KIRKLEES METROPOLITAN COUNCIL INVESTMENT & REGENERATION SERVICE

DELEGATED DECISION TO DETERMINE PLANNING APPLICATIONS

Reference No:	2023/62/93649/W
Site Address:	25, Greenlaws Close, Upperthong, Holmfirth, HD9 3HN
Description:	Demolition of existing garage and erection of two storey side extension with associated external alterations
Recommending Officer:	Molly Storer

DECISION – REFUSED

Proposed Block Plan

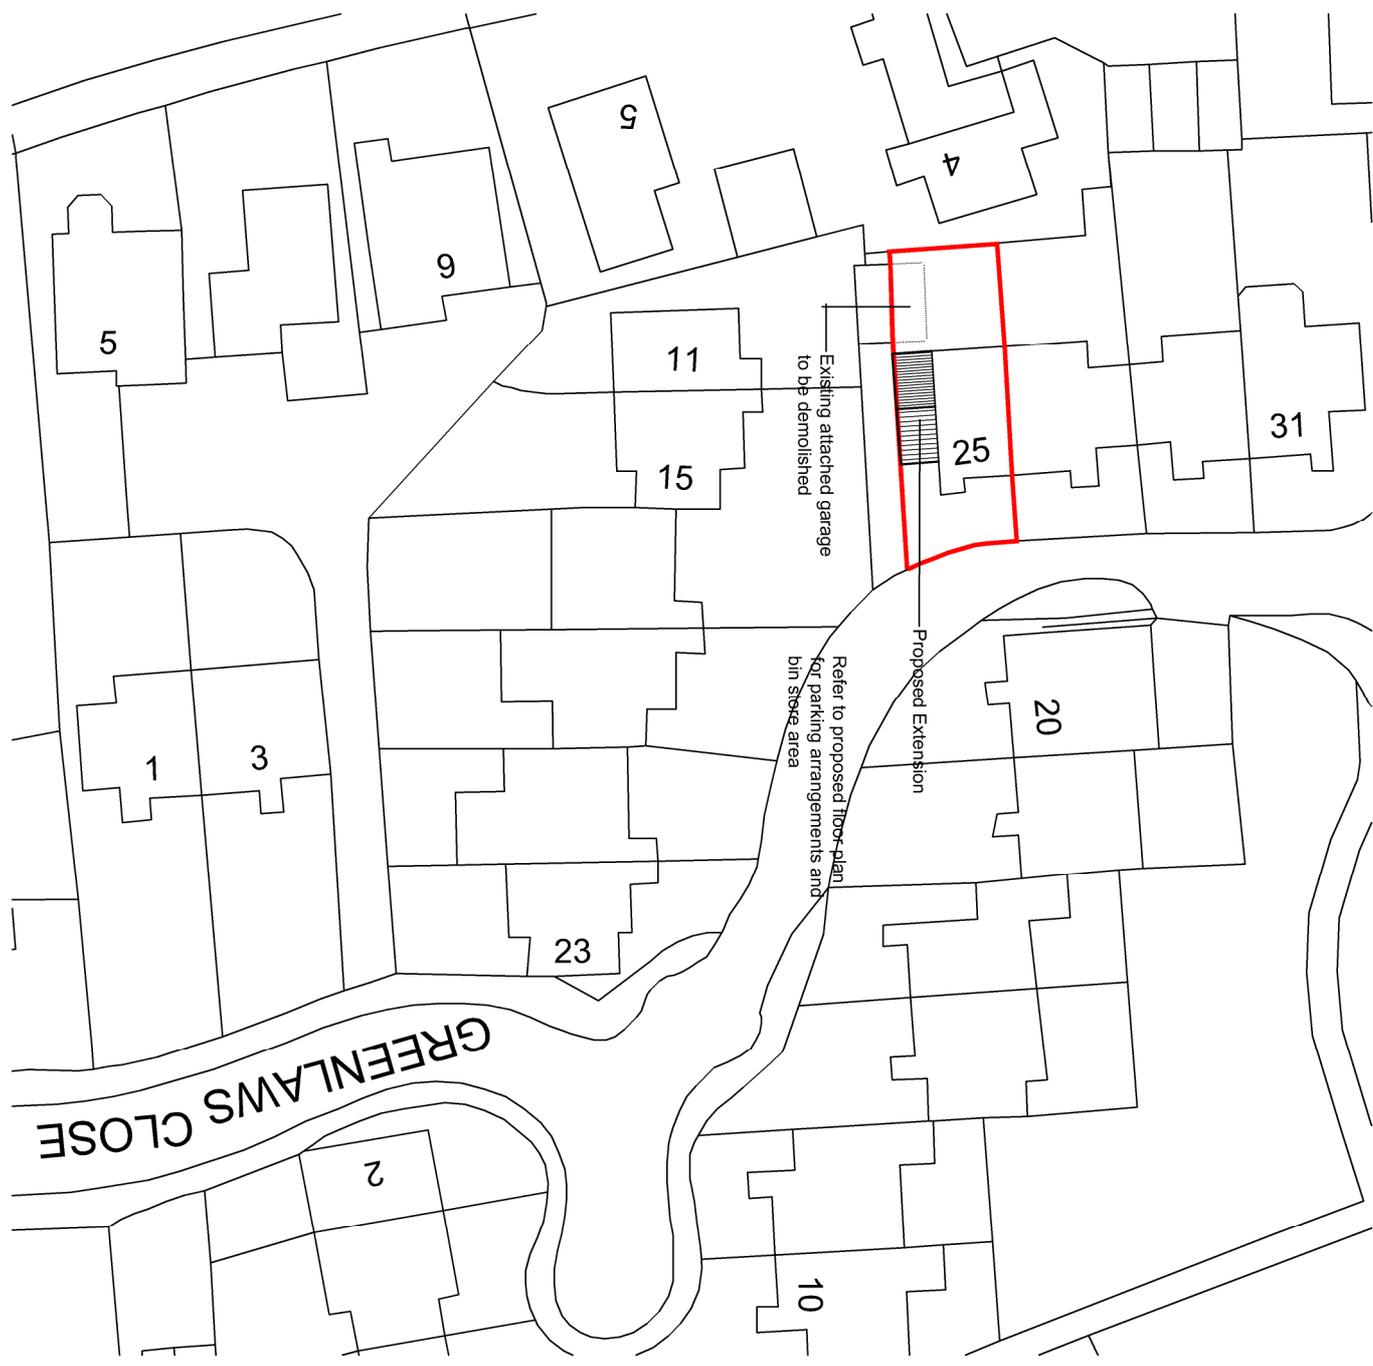
Whilst there is a separation provided by the neighbours detached garage and driveways, given the gap between the properties would be approximately 10m and there is a land level difference with the neighbouring property occupying a lower position, it is considered that the extension would result in an overbearing addition thereby affecting the amenities of the occupiers of the properties to the south of 25 Greenlaws Close.

However, the resultant impact in terms of the proposal would be significant in relation to the overbearing impact and it is considered that the development would be such that it would be unduly oppressive and have a harmful impact in relation to the outlook from these properties. The close proximity of the proposal, coupled with the level of massing immediately opposite the front of nos.11 and 15 would be significant and further exacerbated by the fact that both nos. 11 and 15 are at a lower ground level.

The proposed side extension, by reason of the elevated land level and limited separation of approx. 10m, would result in an overbearing impact and be

oppressive, having a harmful impact upon the outlook of 11 & 15 Greenlaws Close. To permit the proposals would be contrary to Policy LP24 of the Kirklees Local Plan, KDP6 of the House Extensions & Alterations SPD and policies within Chapter 12 of the National Planning Policy Framework.

1. The proposed side extension by virtue of its massing, siting and scale together with the elevated ground levels in relation to nos.11 & 15 Greenlaws Close would have an unacceptably harmful overbearing and oppressive impact to the occupiers of those properties and detrimental impact to the outlook of those properties. To permit the proposal would be contrary to Policy LP24(b) of the Kirklees Local Plan, policy 2 of the Holme Valley Neighbourhood Development Plan, principle 6 and paragraph 5.22 of the House Extensions & Alterations SPD and paragraph 135 of the National Planning Policy Framework.
